20 February 2020

**Planning Act 2008 (as amended) and The Infrastructure Planning (Environmental Impact Assessment) Regulations 2017 (the EIA Regulations) – Regulations 10 and 11**

**Application for MVV Environment Ltd (the Applicant) for an Order granting Development Consent for the Medworth Energy from Waste Combined Heat and Power Facility**

### **Scoping Consultation**

Figure 3.19i
New Bridge Lane access proposal

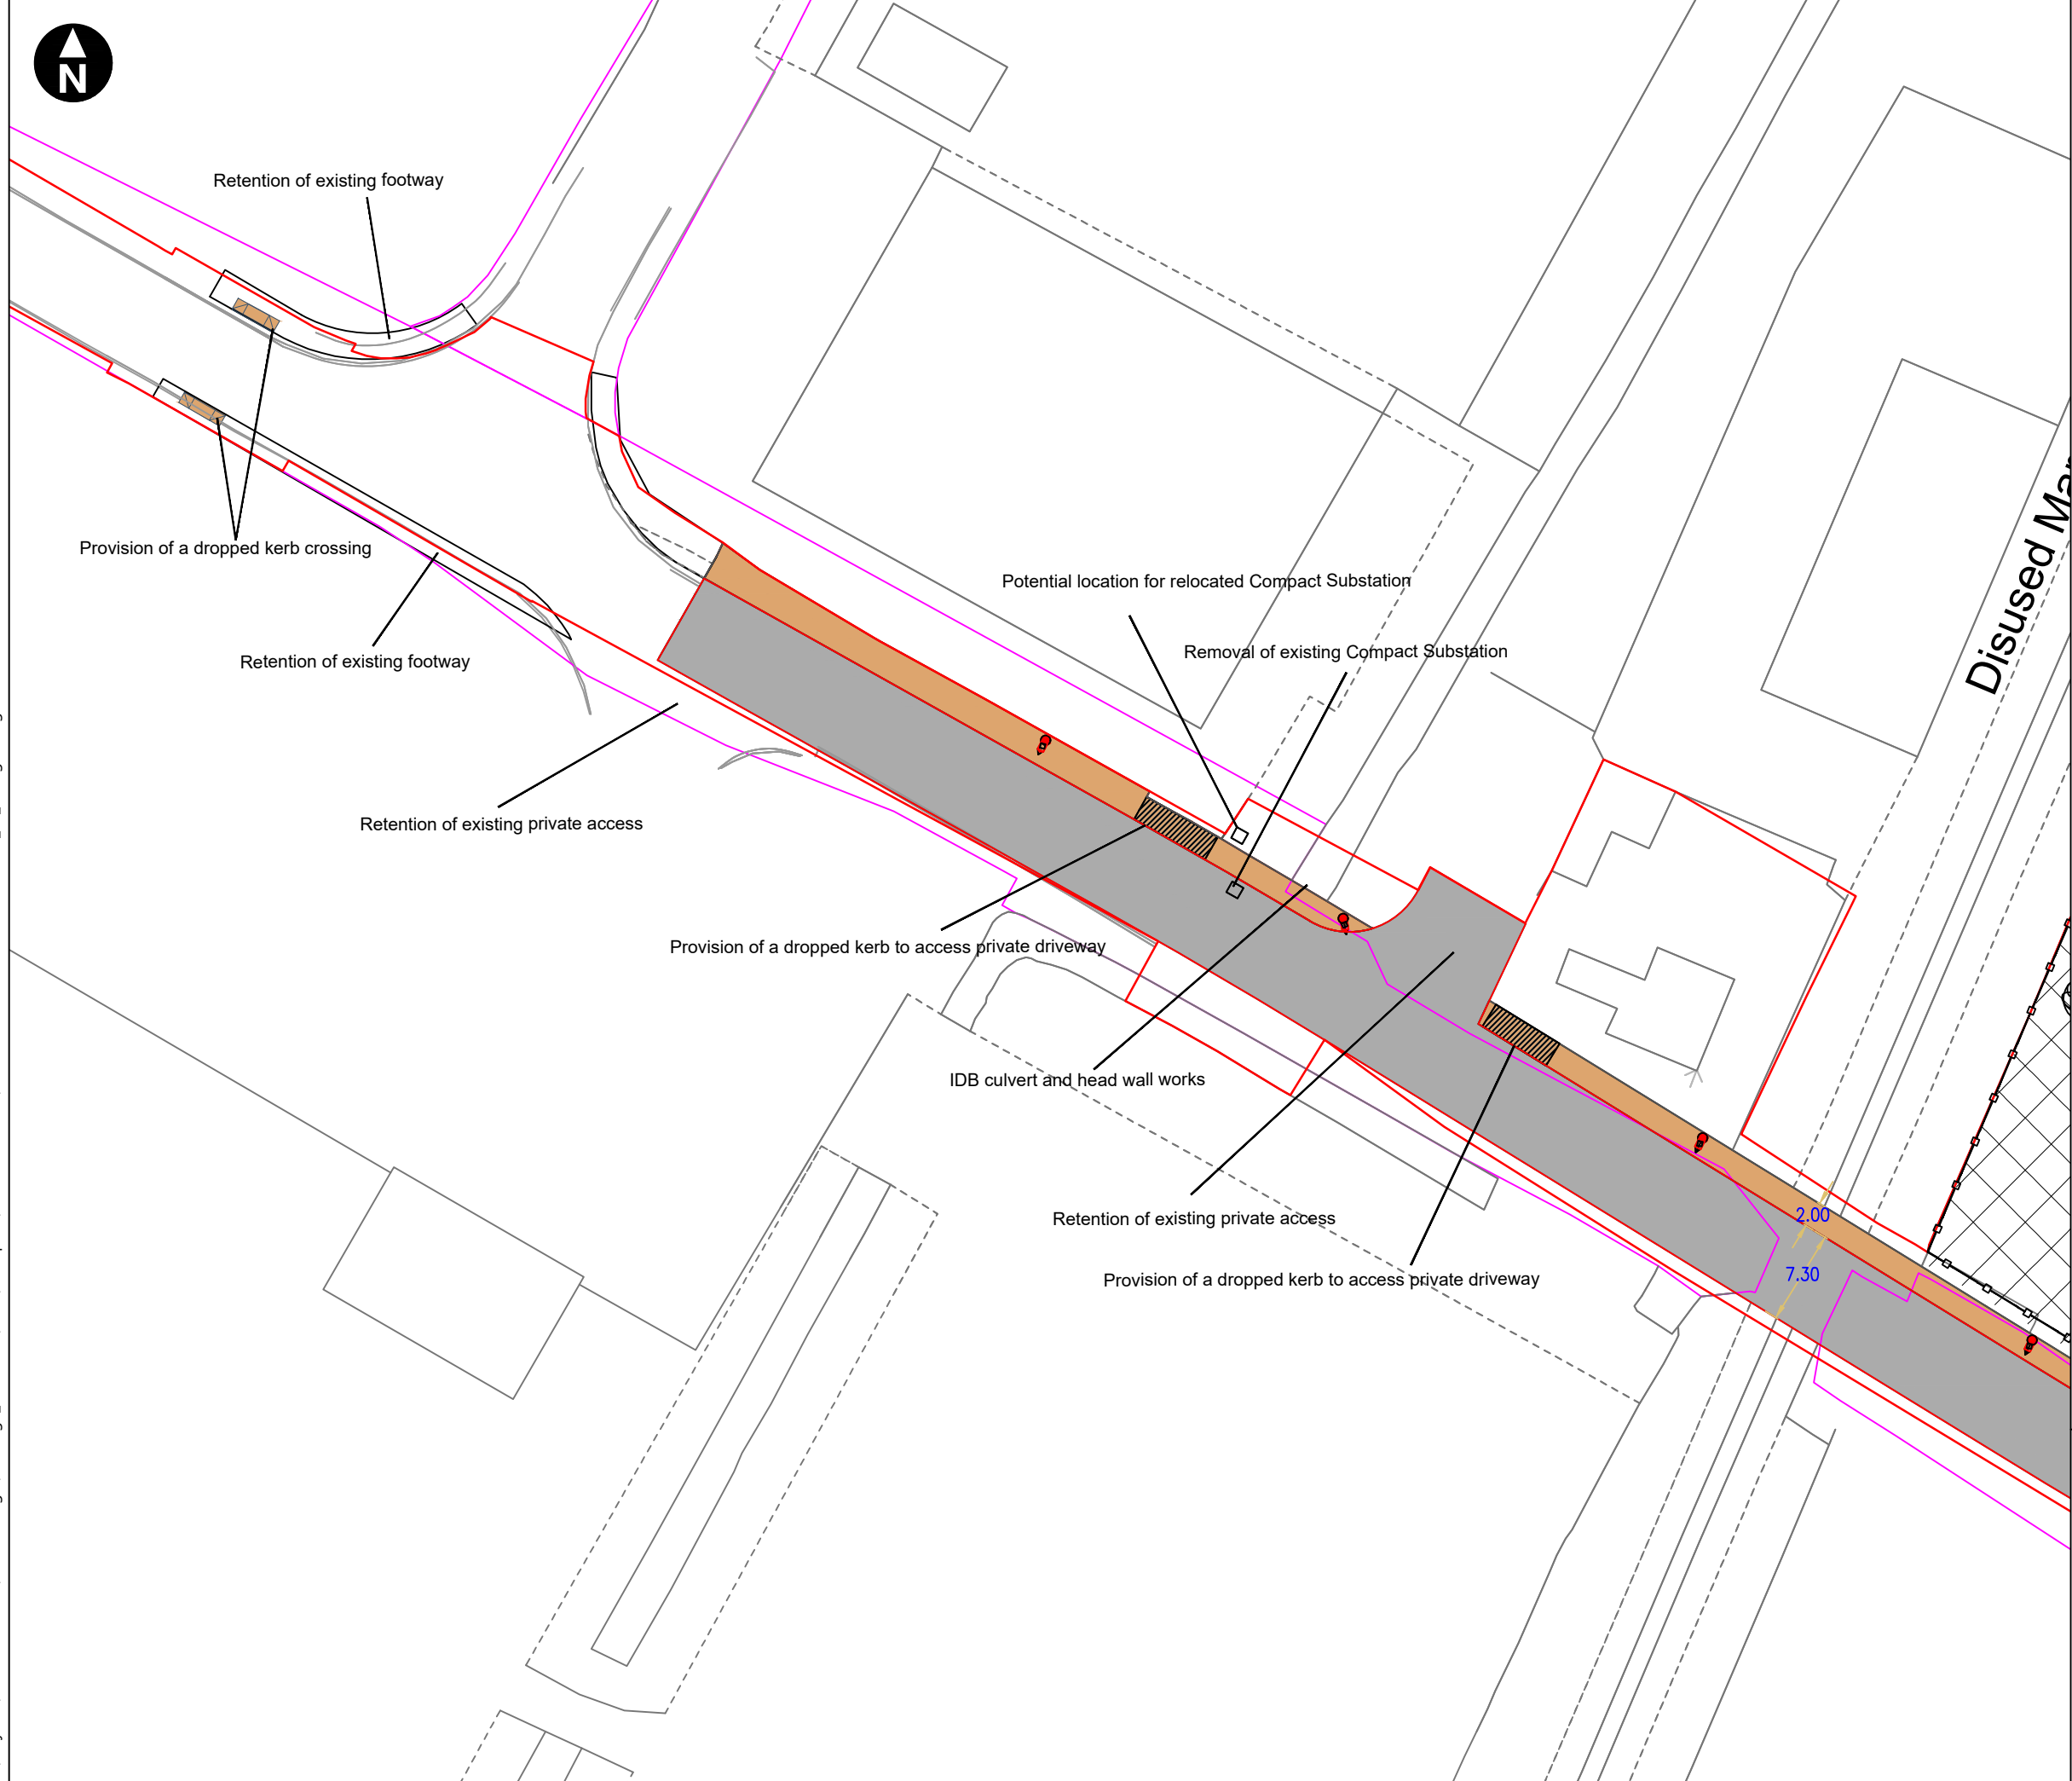
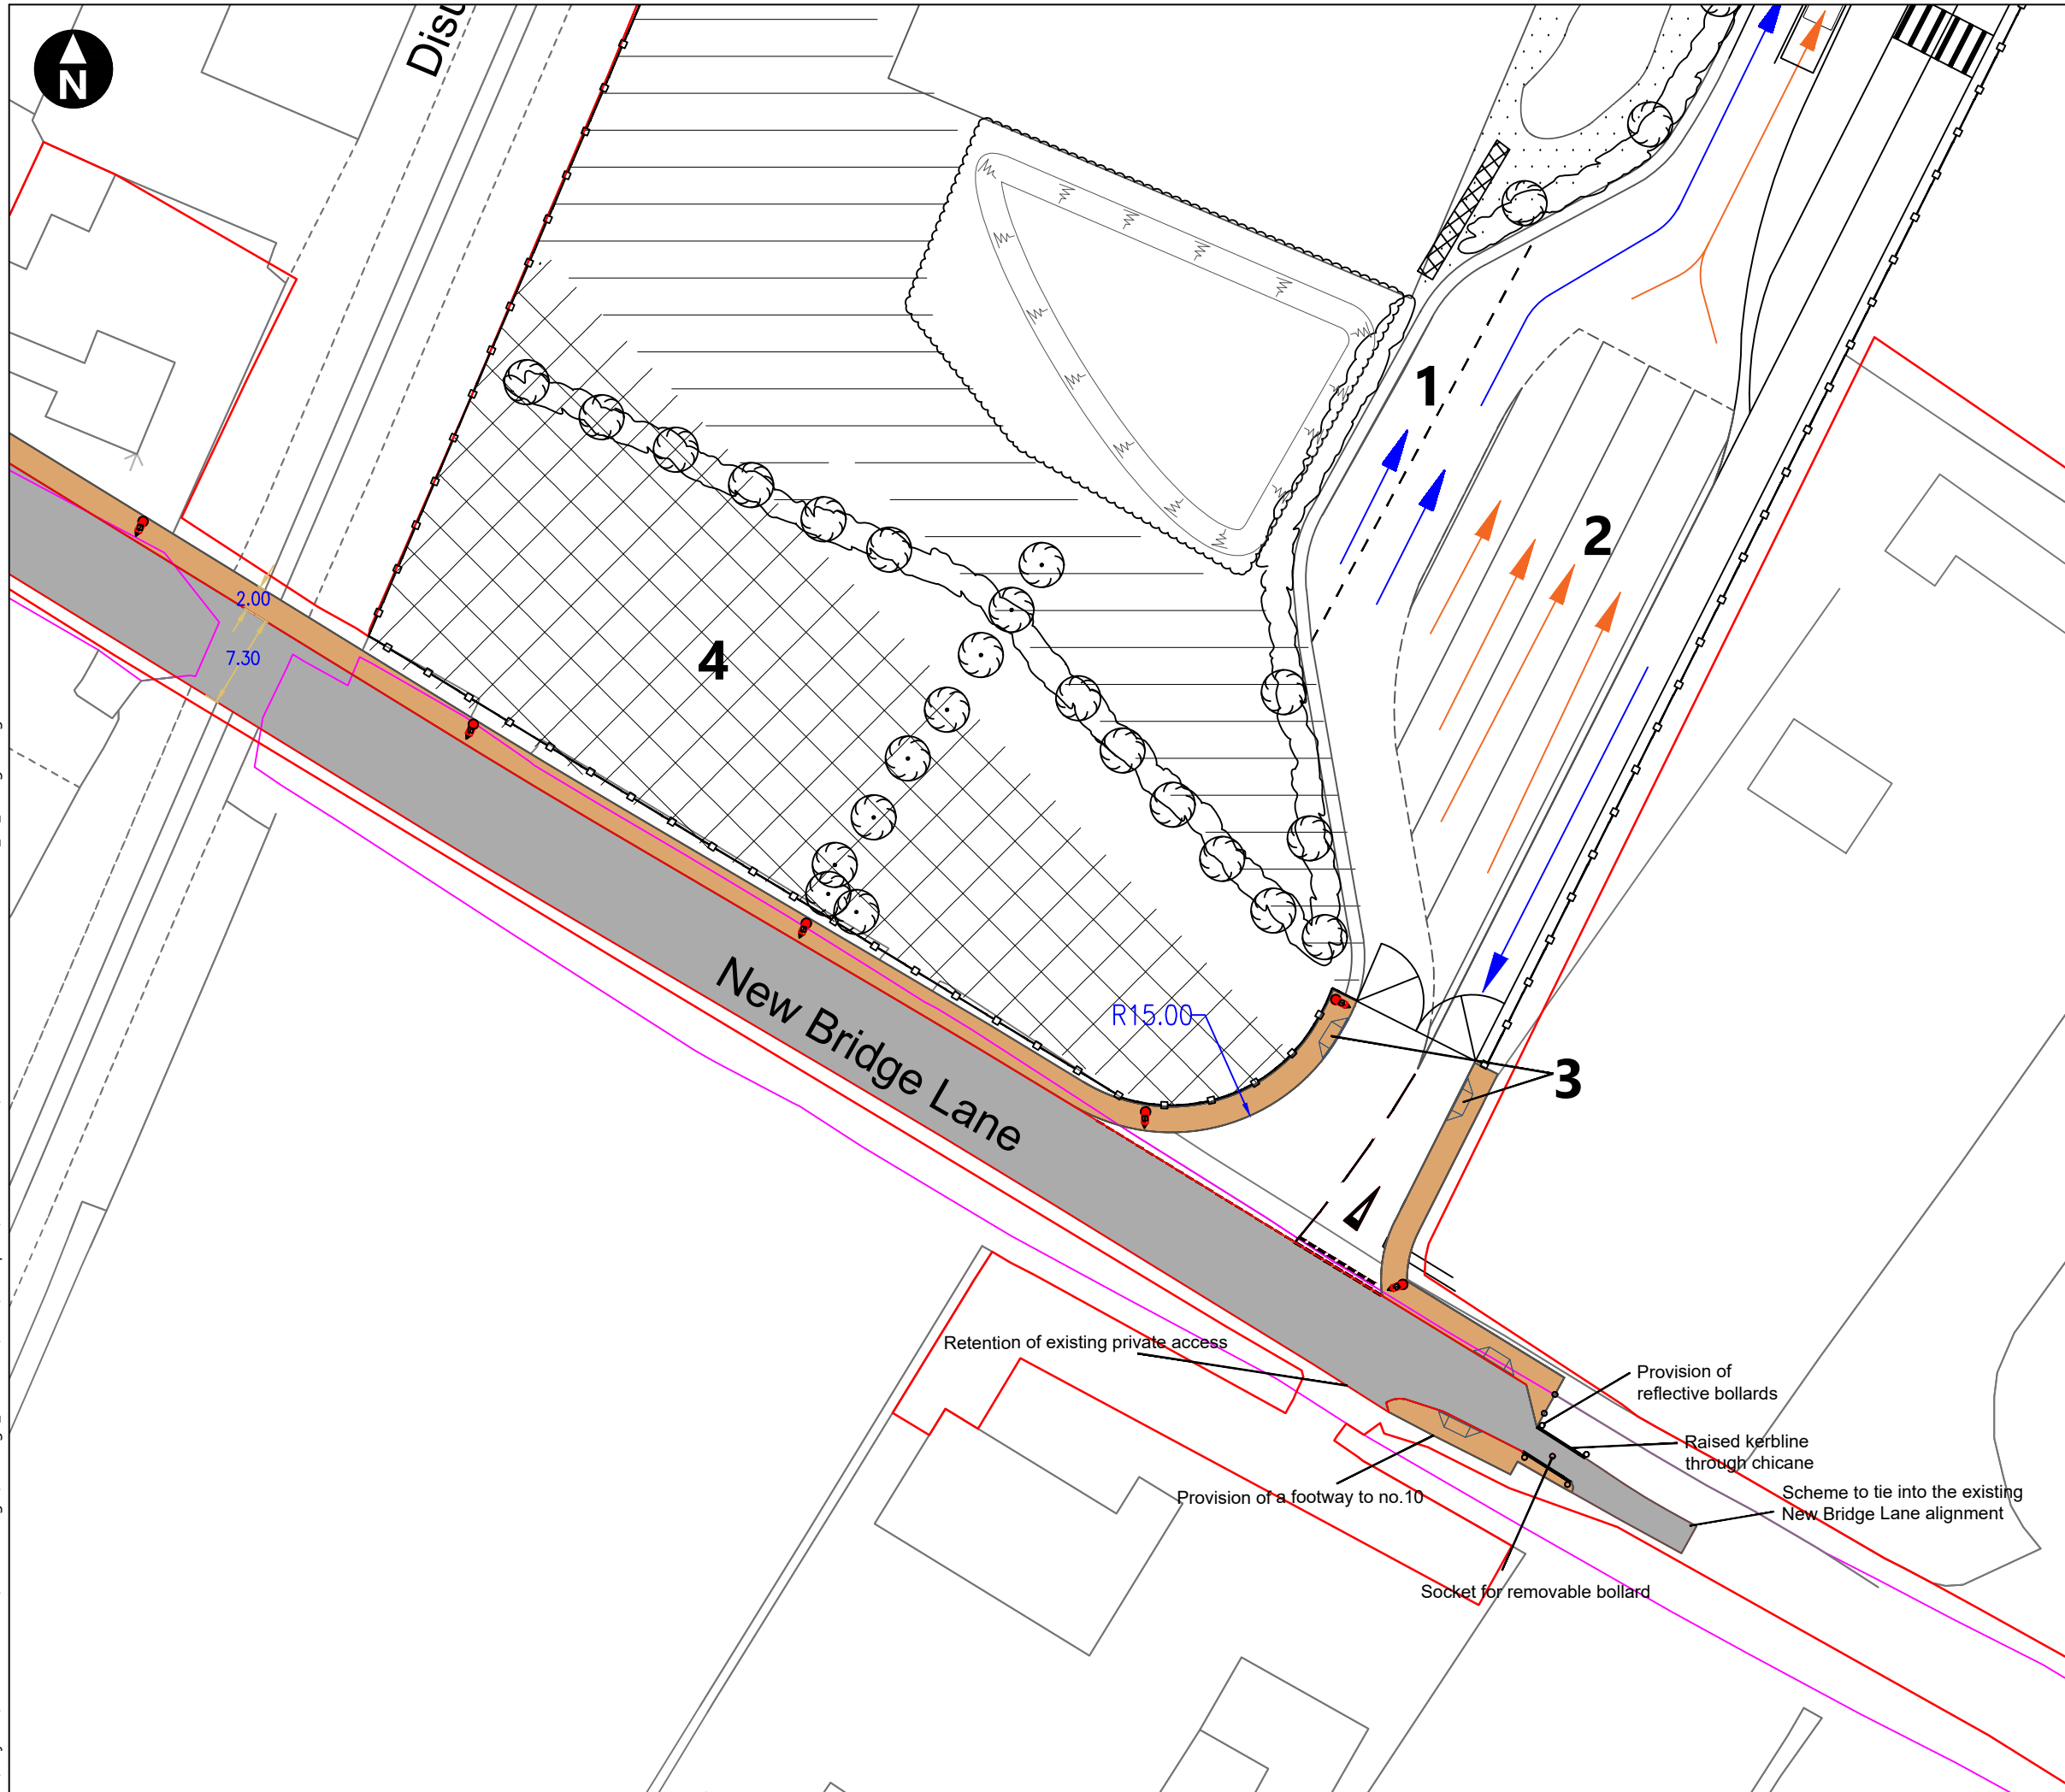
With regard to Traffic and Transport, we agree with the Inspectorate's comments that the developer should consider an alternative route to the site from the South along New Bridge Lane, instead of the proposed route along Elm High Road. The air quality implications of this new access route should be included within the EIA. Furthermore, we agree that more detail is required with regard to the number, type and timings of vehicle movements accessing the site during both the construction and operational phases.
